**KIRKLEES METROPOLITAN COUNCIL
INVESTMENT & REGENERATION SERVICE**

DELEGATED DECISION TO DETERMINE PLANNING APPLICATIONS

Reference No:	2024/62/90416/W
Site Address:	Former Hall Ing Quarry, Hall Ing Road, Brockholes, Holmfirth, HD3 3FR
Description:	Erection of one dwelling
Recommending Officer:	Tom Hunt

DECISION - REFUSE

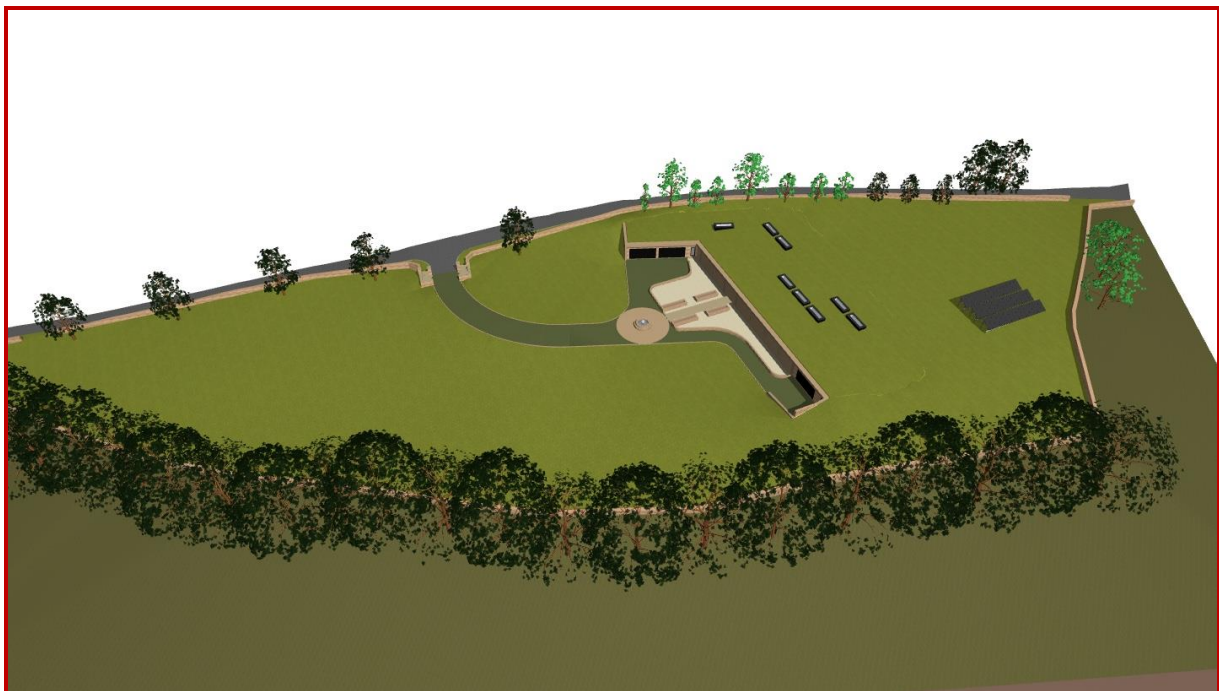
The proposal would be a single storey structure with only the front elevation visible and the rest covered with landscaping. It would blend in with the existing contours and topography of the site and would allow significant greening within the land together with insulation for the building. The roof would not cause any increase in height beyond the existing contours of the quarry. Furthermore, the submitted plans show the dwelling to be constructed from stone on visible elevations and reconstruction of drystone boundary walling which is a natural material that would blend in with the rural landscape.

The sheltered nature of the design set within the site contours and green roofed would however lead to a secluded design that would have minimal/no impacts on long distance views. In addition, the use of drystone walling typical of the area would relate positively to the character and function of the landscape under Principles 2 and 8 of the SPD and Policy 1 of the Holme Valley Neighbourhood Development Plan.

It would introduce some urbanising features within its pleasant rural setting such as significant alterations to the site with extensive hardsurfaced areas, alien features such as solar panels and rooflights and excessive use of glazing. However, this would remain predominantly screened by surrounding topography and woodland in long range views, and would have its driveway in grasscrete construction limiting this visual effect with some positive benefits in energy generation.
